From: Geoff Gibbs [REDACTED]
Sent: 20 November 2020 12:37
To: Planning <Planning@arun.gov.uk>; Michael Eastham <Michael.Eastham@arun.gov.uk>
Subject: A/179/20/RES Land South of Water Lane, Angmering, Approval of reserved matters etc.

A/179/20/RES Land South of Water Lane Angmering Approval of reserved matters (appearance, layout & scale of access only) following A/99/17/OUT for a culvert & associated access over the Black Ditch providing access to the approved development. This application may affect the setting of a listed building & falls within Strategic Site SD9, CIL Zone 1 (Zero Rated).

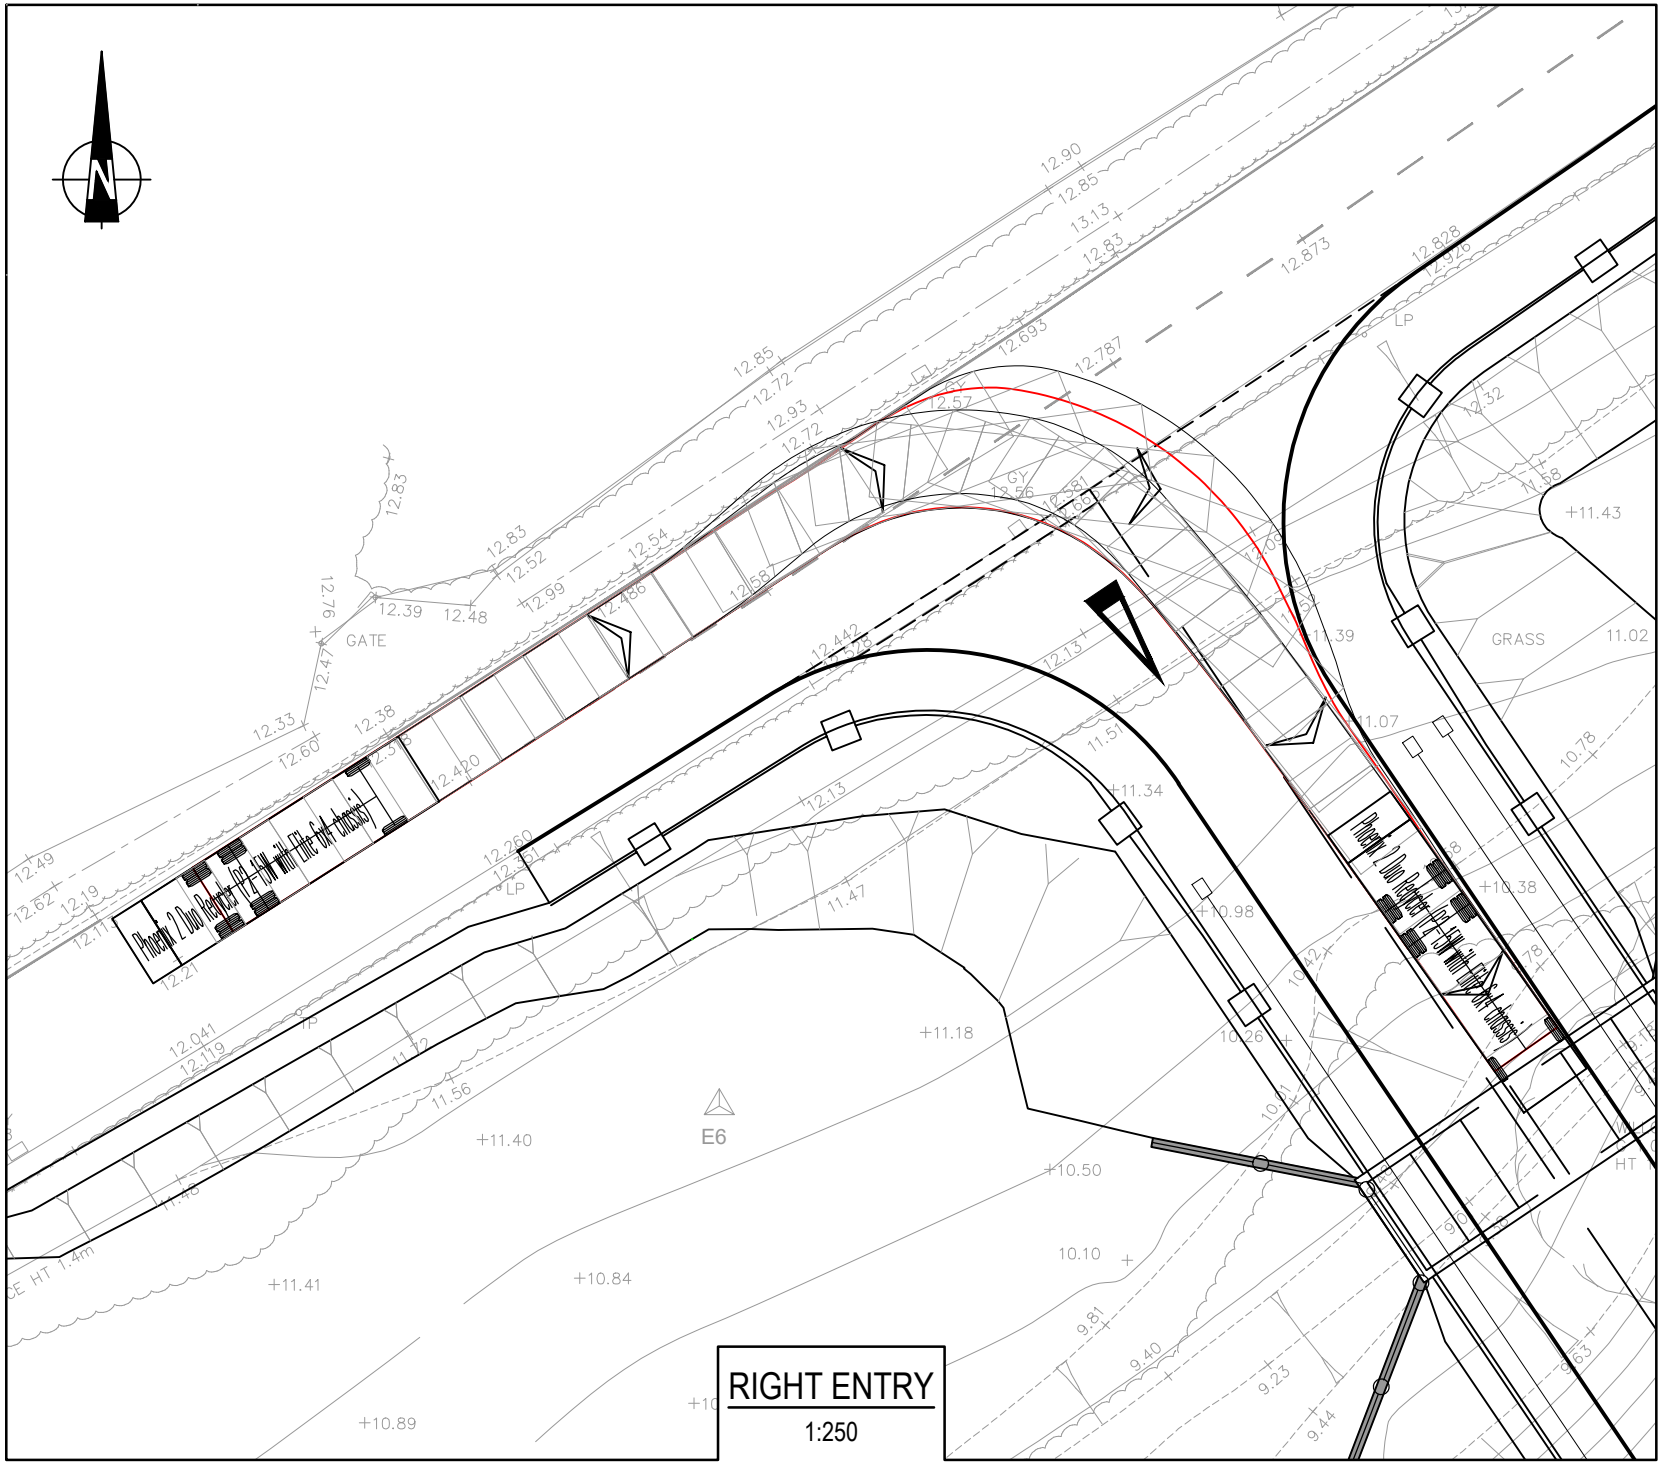
I write to object to the proposal for a temporary access to the development site for construction purposes from the eastern end of High Street. The use of the narrow High Street for this particular site is entirely inappropriate because it is simply unnecessary.

A 'construction management plan' dated 28th October 2020 was posted on your website on 29th October 2020 but quickly replaced on 13th November 2020 with a substitute 'construction management plan' dated 9th November 2020. The most significant aspect of this 'plan' is the proposal to use a narrow site access at the eastern end of the similarly narrow High Street for construction purposes for the early part of the construction phase. The early part of developing any housing site requires a disproportionately large number of vehicle movements and particularly much larger vehicles. This, as civil engineers know, is because the early part of the construction period involves building highway and drainage infrastructure and here this includes a permanent crossing of the Black Ditch.

It is unclear what access alternatives were considered because none were documented. It seems obvious that there should be a temporary construction access to the site from Water Lane some distance to the east of the proposed site access. Water Lane in this area, unlike High Street, has limited frontage access and is rather wider. A competent contractor could easily and safely cross the Black Ditch with a temporary access.

If you are minded to approve this temporary access off High Street will you please consider carefully its impact on walkers? Besides High Street leading to the footbridge over the A280 'bypass' the eastern end of High Street connects with a southbound track that joins with Cow Lane which, I believe, is a restricted byway.
